The Planning Inspectorate  
Botley West Solar Farm Consultation

**Response to Botley West Solar Farm Development Consent Order (“DCO”) Consultation  
DCO Development: Solar photovoltaic array and connection infrastructure, with a maximum  
intended generation capacity of 840MW  
Client: The Chancellor Masters and Scholars of the University of Oxford**

Title: Illustrative Masterplan
Figure 5.5
 Cable Corridor Plan Overview –
 Land between the Central and Southern Sites east
 and south of Eynsham around the Swinford Bridge

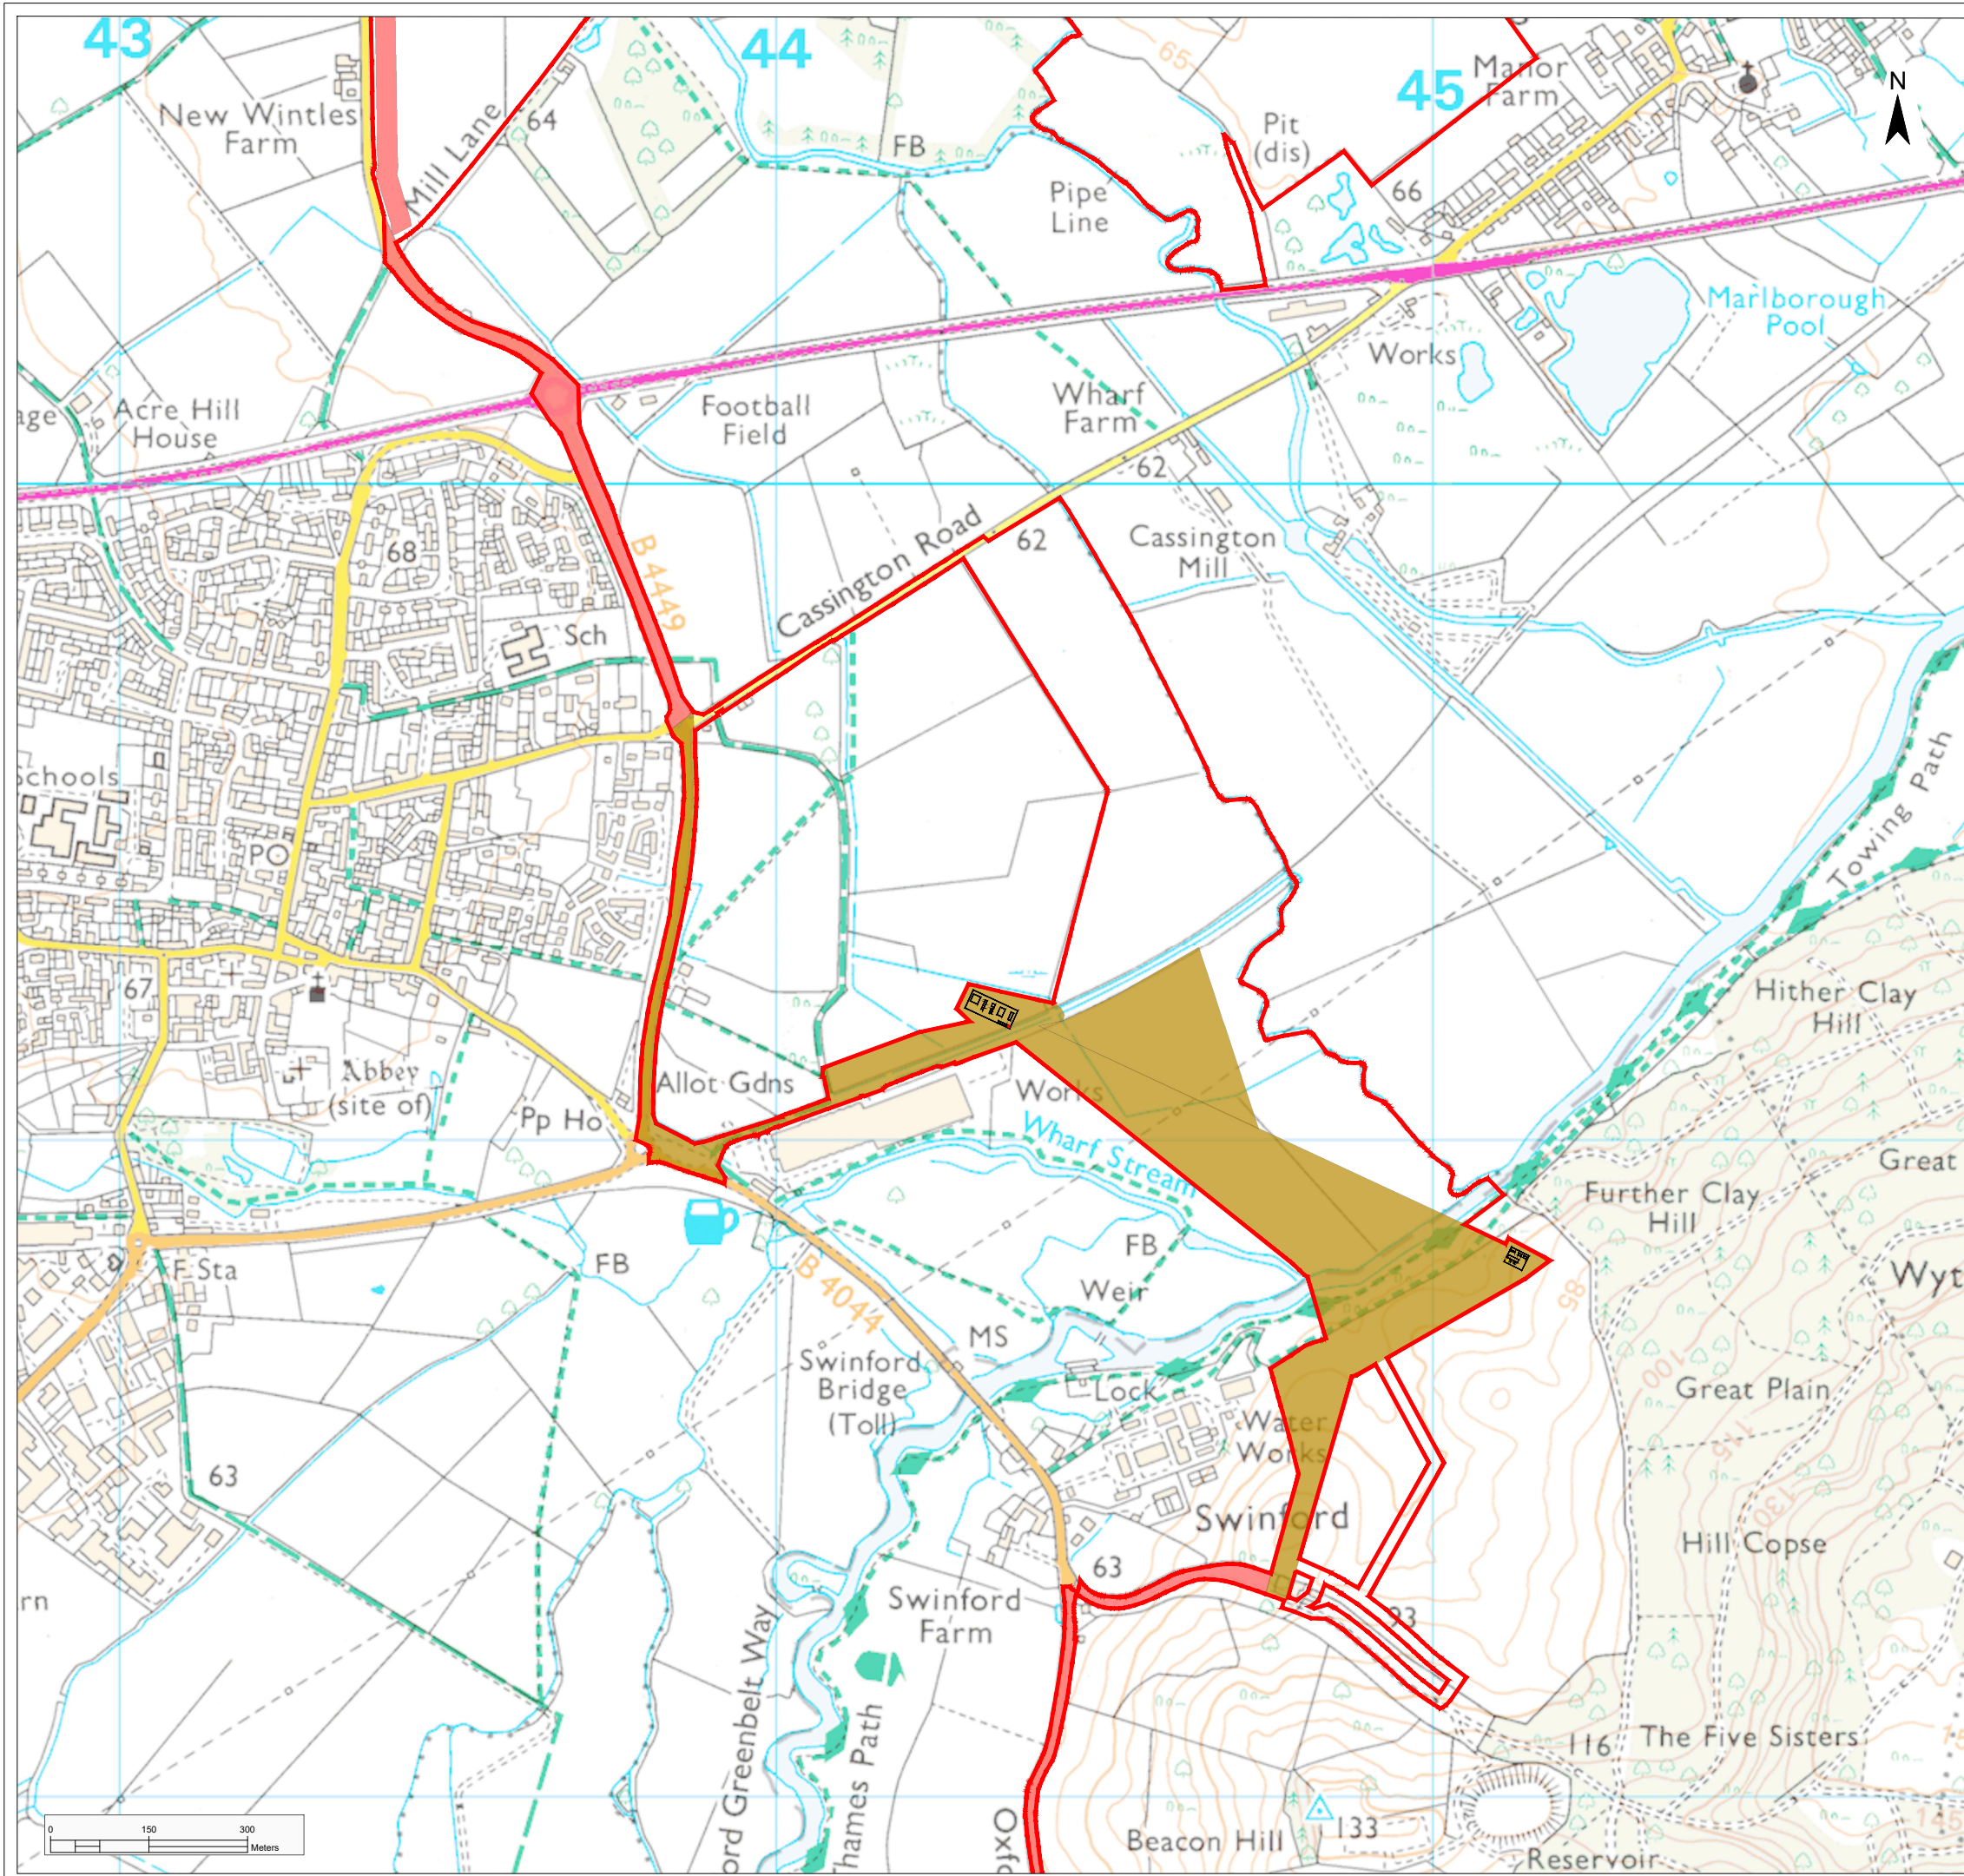
- Cable Routing and Option Choices – the University needs to ensure that its interest and those of its tenants are adequately reflected in the proposed scheme. The University requires assurances as to how the impact on the University’s holdings will be protected when there are multiple options proposed at this stage. It is unclear why further detail or a particular route across the University’s land cannot be narrowed down at this stage.

Uh, that is going to be directly affected by the cable route or one of the cable route options as currently proposed. So again, that is a scheme design matter. And we seek assurances around how that impact is going to be mitigated without that detailed design being available at this stage. Um, there's a significant impact on agricultural use of, uh, of the land. Um, the land that is identified for the cable routing.

I think we have lack of visibility as to alternatives or understanding as to why these cable routing options have been chosen. We we have had engagement through ardent management, suggesting a number of cable routes, but limited information about the whys and wherefores. It just seems to be a sort of fait accompli. So understanding that to mitigate some of the impacts that I've raised, um, would be really helpful.

Okay. Thank thank you very much. And I think I've already asked the applicant at as an action, if you like to, to provide more detail on those routing options throughout the examination so we can narrow those down.
